Office of
Environment
& Heritage

DOC16/358201
SSD 7534

Western Sydney Stadium Concept Proposal and Stage 1 Demolition (SSD 7534)

OEH comments on Western Sydney Stadium Concept Proposal and Stage 1 Demolition (SSD 7534)

CONCEPT PLAN
WESTERN SYDNEY STADIUM CONCEPT PLAN

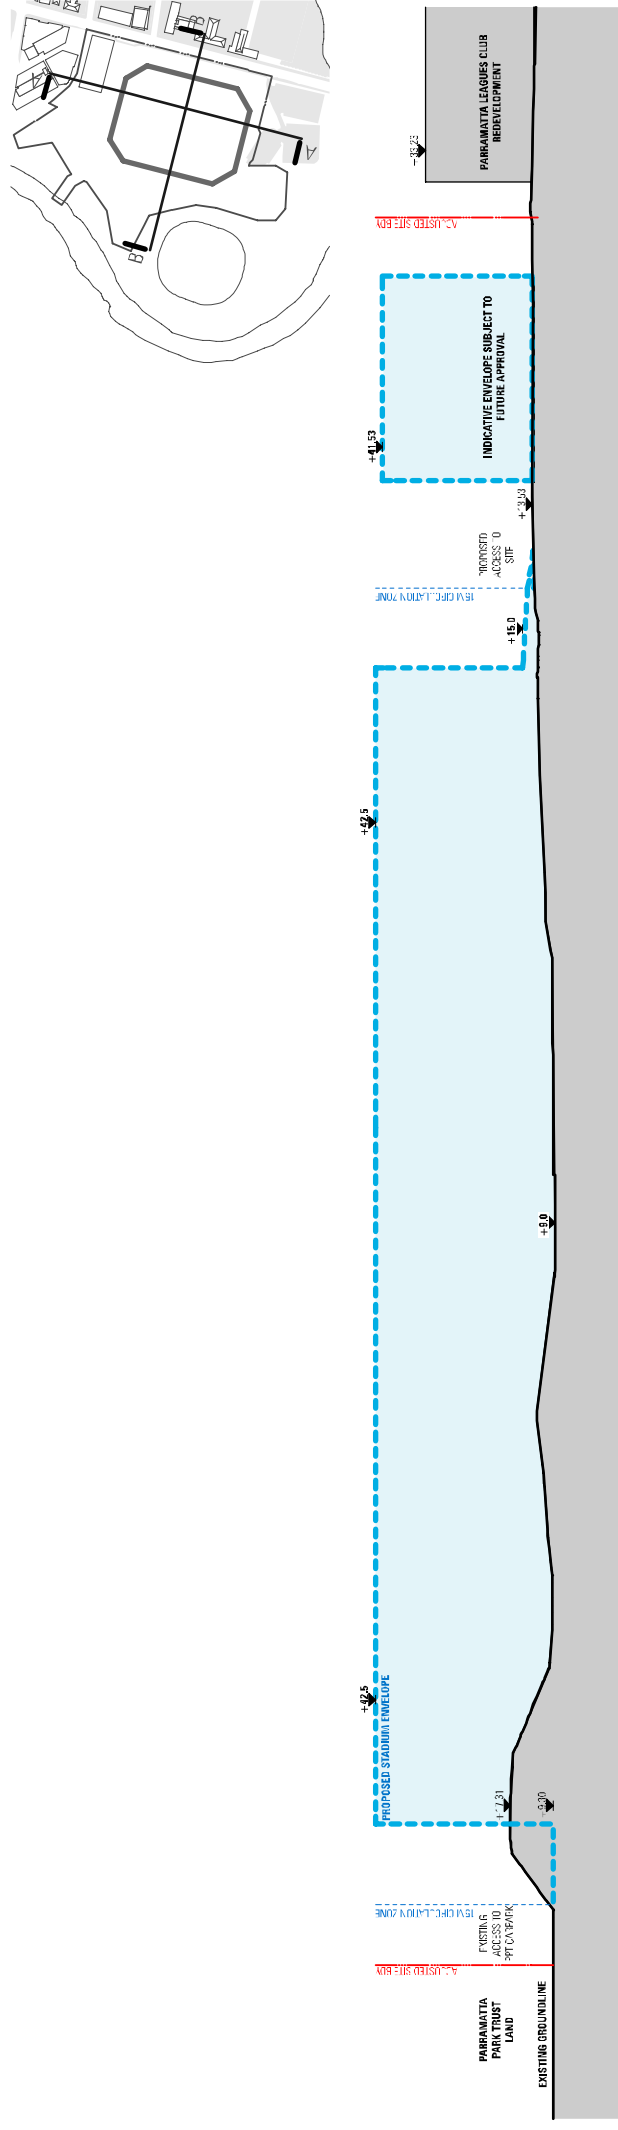
OEH notes that the pedestrian link shown in Concept Proposal Drawing DA03 passes through the camp. Given the increased capacity of the stadium, an increased use of this pedestrian access would also be expected. There is no discussion in the Biodiversity Assessment of potential noise and light impacts on GHFF from the increased use of this pedestrian footbridge, nor any mitigation measures recommended. OEH considers that any lighting along the walkway should be directed away from the camp. Planting of shrubs and trees to shield the camp from lights and noise may also be appropriate.
